**Application by Vattenfall Wind Power Limited for an Order
Granting Development Consent for the Thanet Extension Offshore
Wind Farm**

Local Impact Report

Dover District Council

Date: 15th January 2019

**Figure 12.1a**

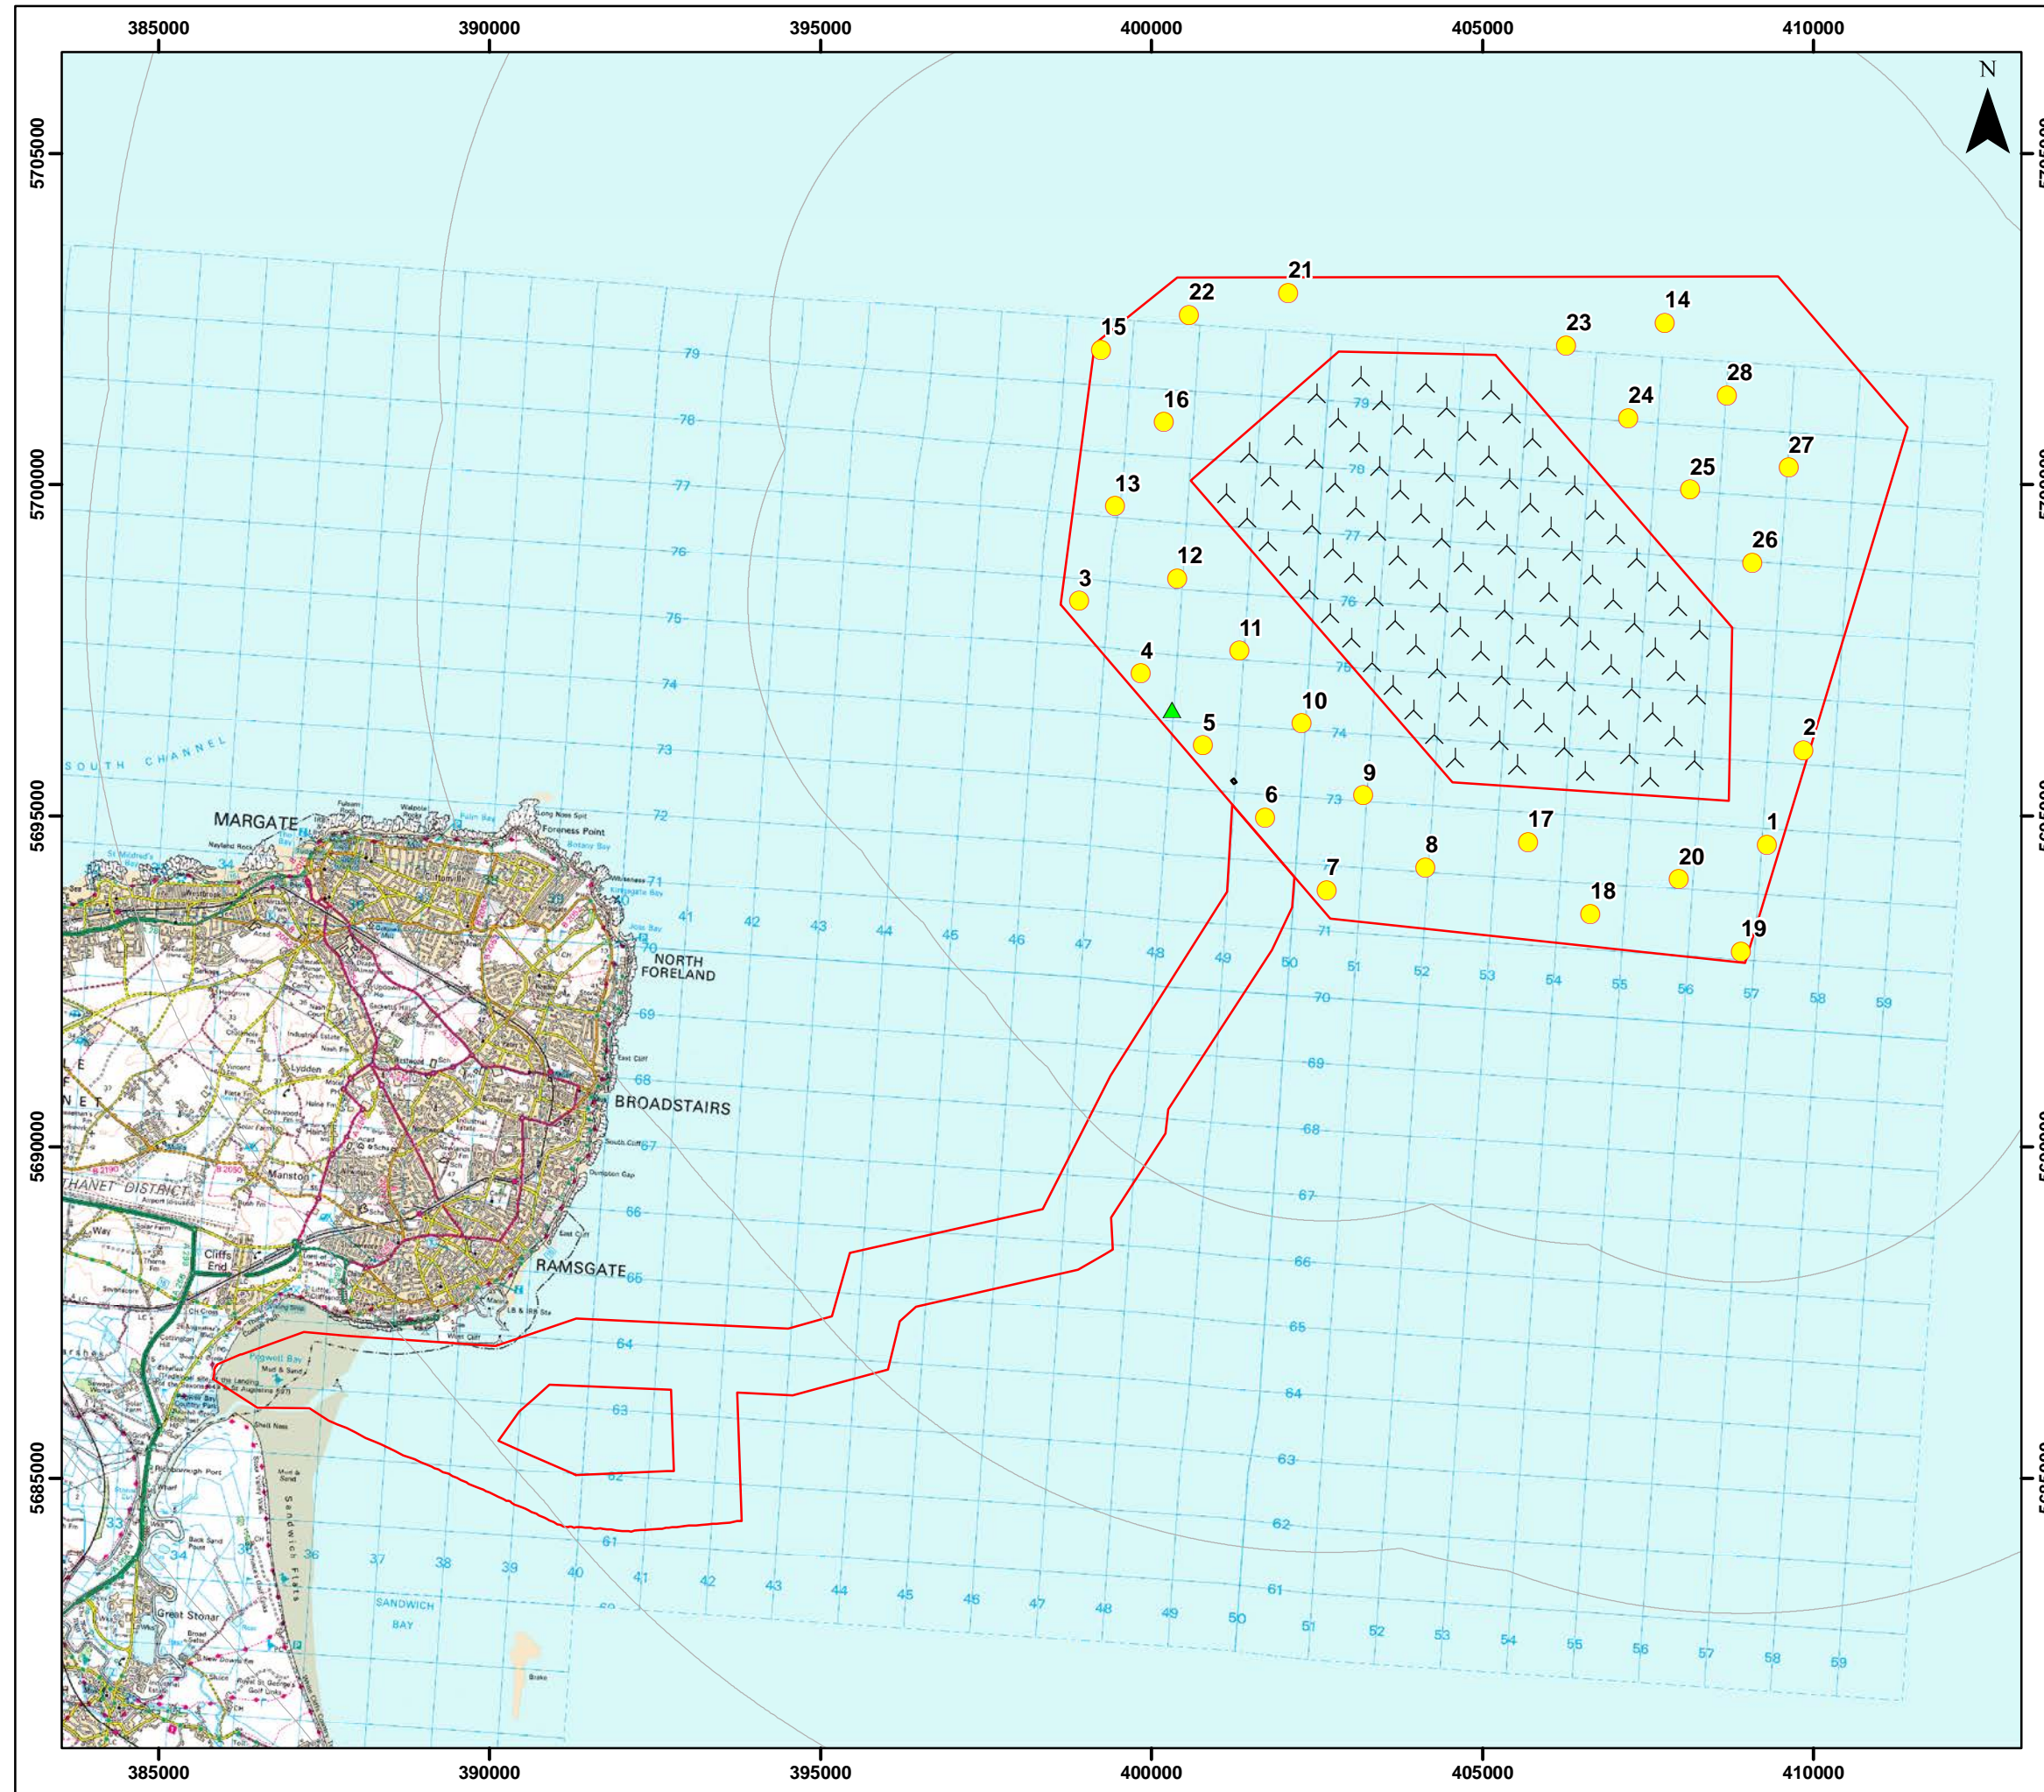
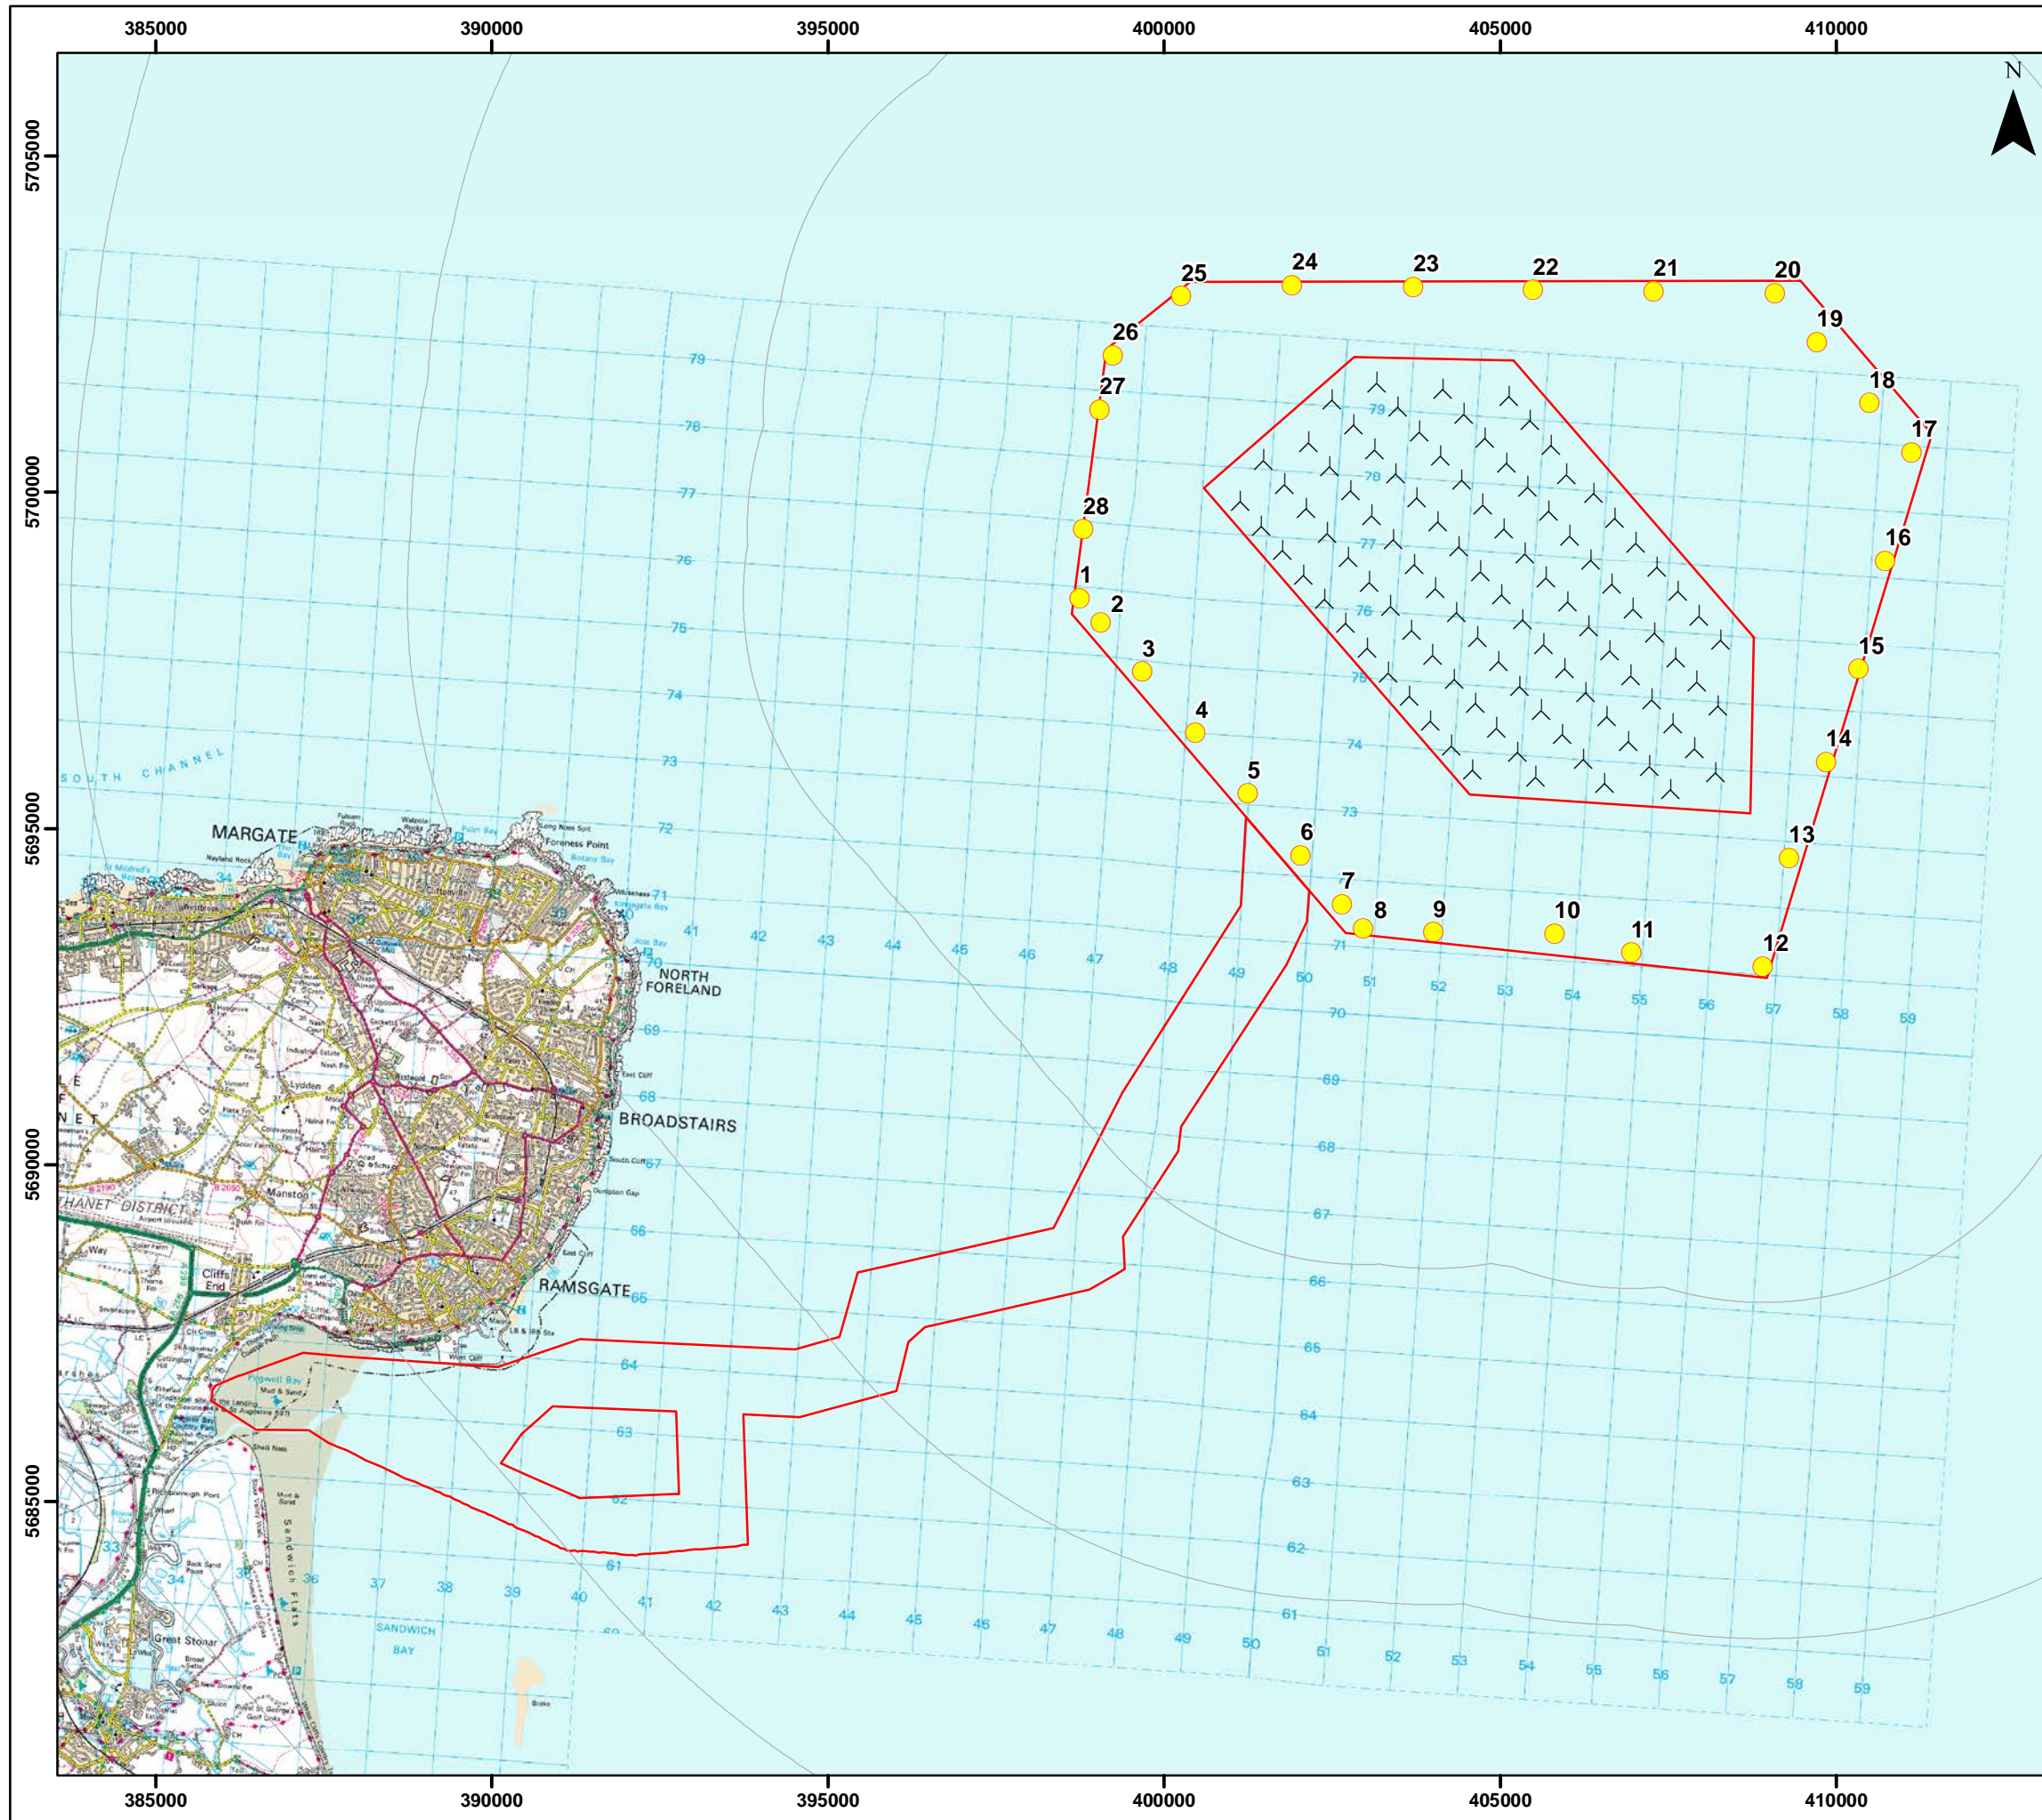
3.3.6. DDC would also suggest that the Optimum Space Layout (Fig. 12.1 in ES Volume 6 Annex 12-1 Rev A – Doc Ref 6.6.12.1) to site the array in closer proximity around the existing offshore array may minimise the visual spread across the seascape which could mitigate some of the visual impact over a wider area. Any reduction in the extent of the array in a southerly direction could mitigate or remove DDC's concern regarding the visual impact on the seascape from DDC's administrative area.
